From: Michael Gray <Michael.Gray@rfs.nsw.gov.au>
Sent: Tuesday, 15 February 2022 11:08 AM
To: DPE CSE Information Planning Mailbox
Cc: Alex Wang
Subject: NSW RFS Draft Letter of response to DPE for Project Energy Connect (NSW Easter Section) NSW SSI-9172452

Your reference: SSI-9172452

Development Application
Other – Part3A – Electricity Generating Works
Project Energy Connect (NSW Easter Section) NSW

A review of the Bushfire Impact Assessment (Technical Paper 12) prepared by Australian Bushfire Protection Planners Pty Ltd, dated December 2021 has been undertaken with focus on Chapter 5, Table 5.1 'Mitigation Measures'. The following NSW RFS Comments are provided as recommended inclusions/amendments/comment for each mitigation measure (where relevant).

Figure 4-15 Elevation of the indicative proposed vegetation clearing requirements within the 330kV transmission line at tower locations – operational phase

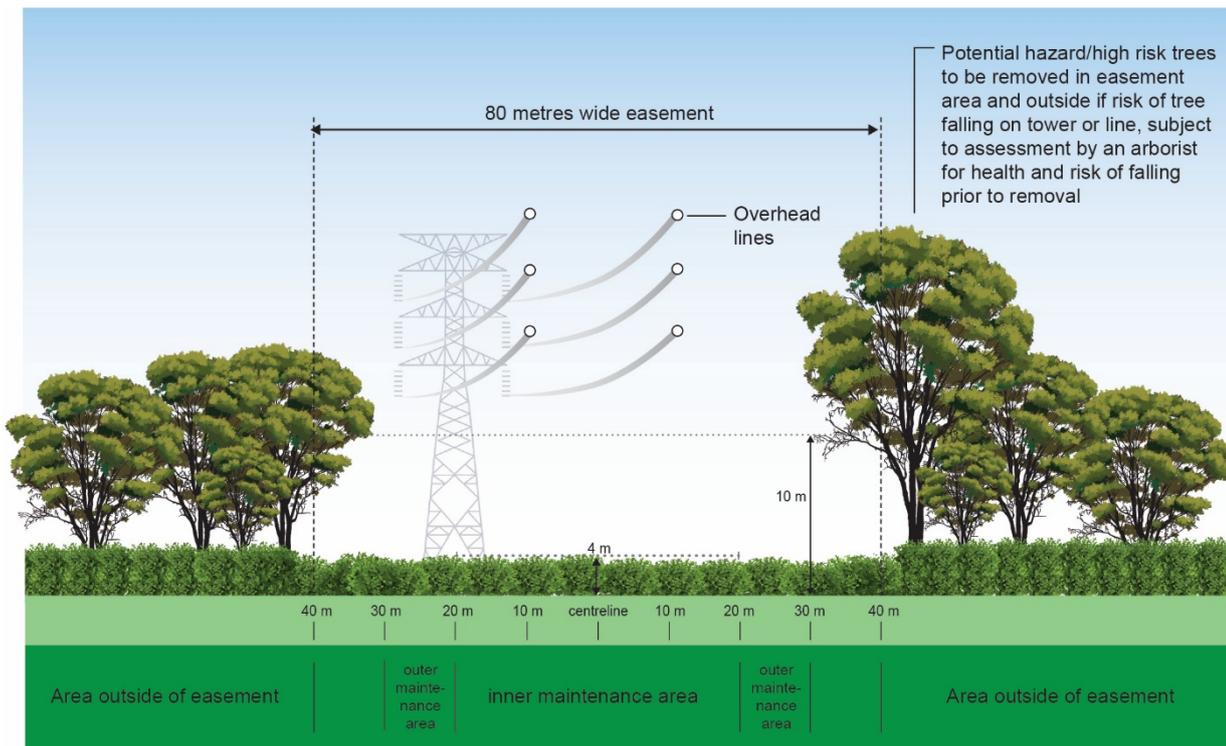
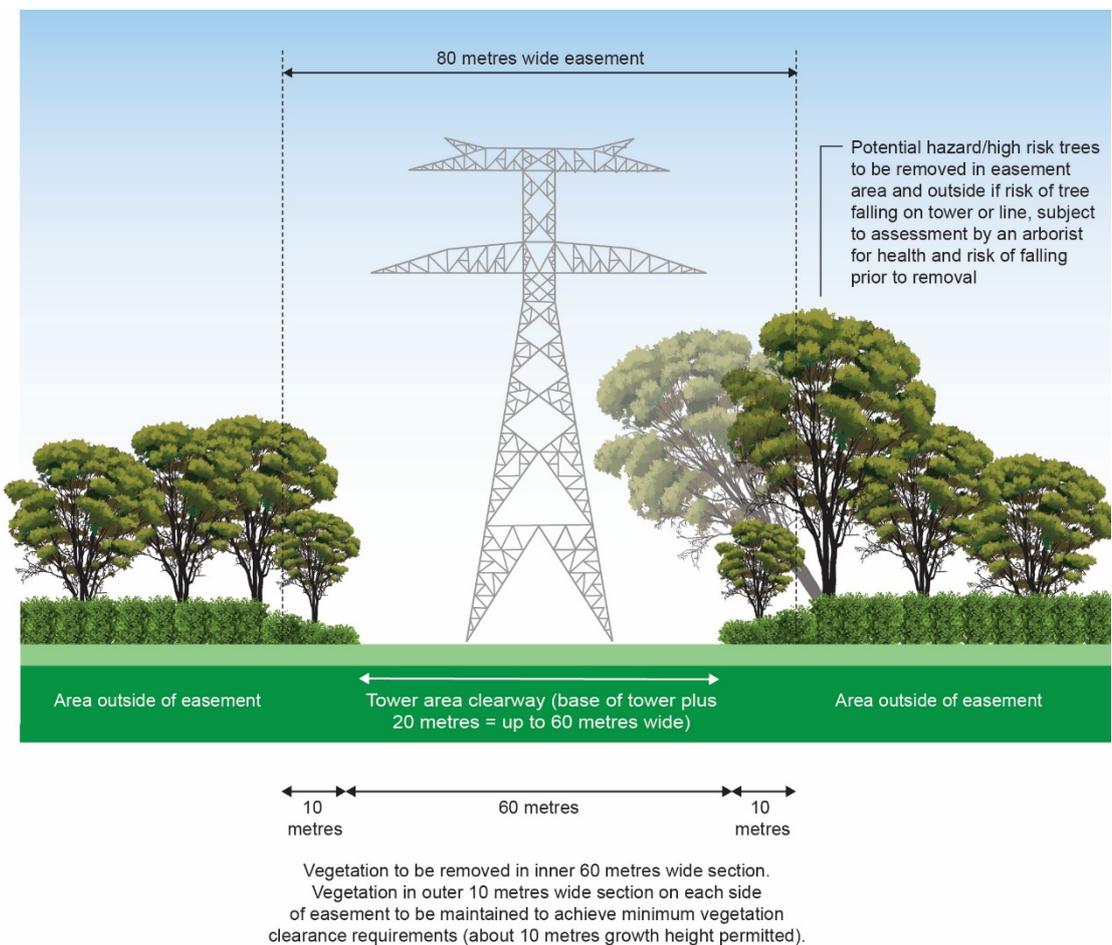
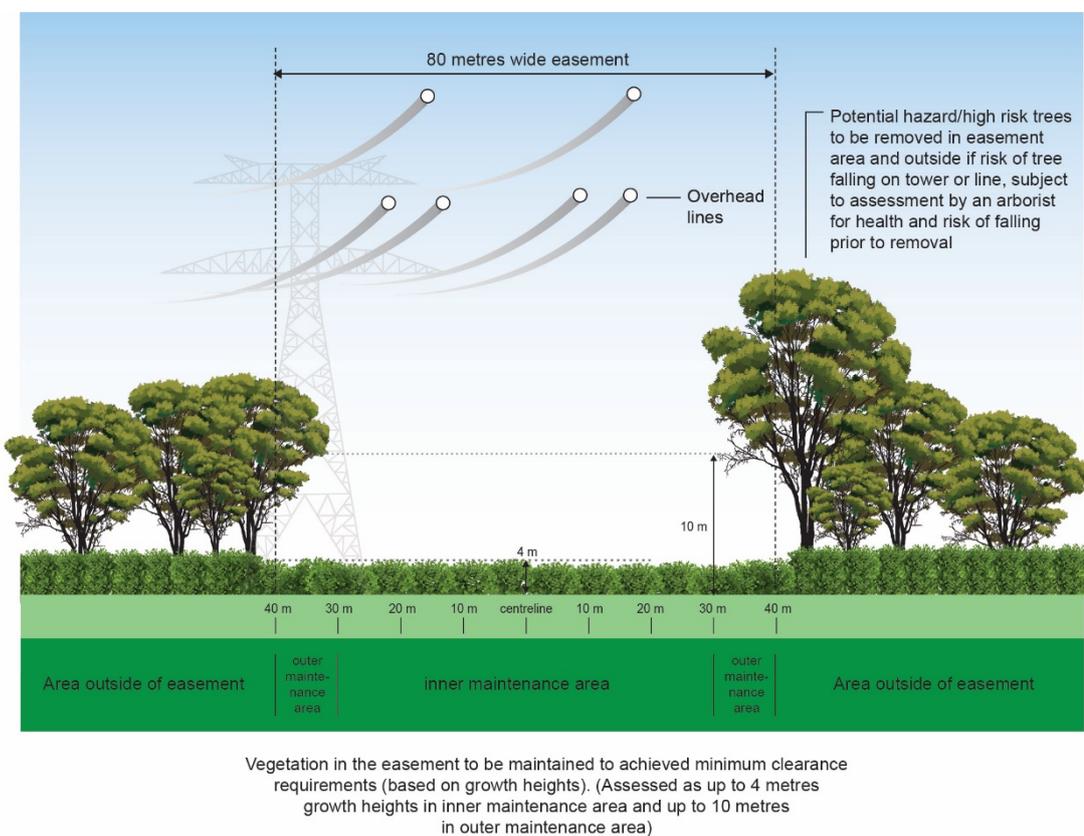
The NSW RFS would recommend that vegetation management works should achieve the standards of an Asset Protection Zone (APZ) around all assets that avoids potential flame contact,

and mitigates radiant heat (providing for reduced ignition and heat damage and a safer environment for fire fighters to operate).

As such, all structures (transmission lines, substations, camps, ancillary works etc) should be designed with materials that withstand the applicable radiant heat level (kW/sqm) and any flame contact from surrounding vegetation.

The above referenced vegetation management standards in the Bushfire Impact Assessment do not demonstrate this is being achieved. In particular, the proposed revegetation height within the inner maintenance zone of up to 4-10 metres, may result in substantial flame contact and radiant heat impacting the assets. The NSW RFS recommends this is further investigated, and that the approval authority be satisfied that the proposal provides a suitable level of bush fire protection particularly with regard to vegetation management standards surrounding the length of the transmission lines.
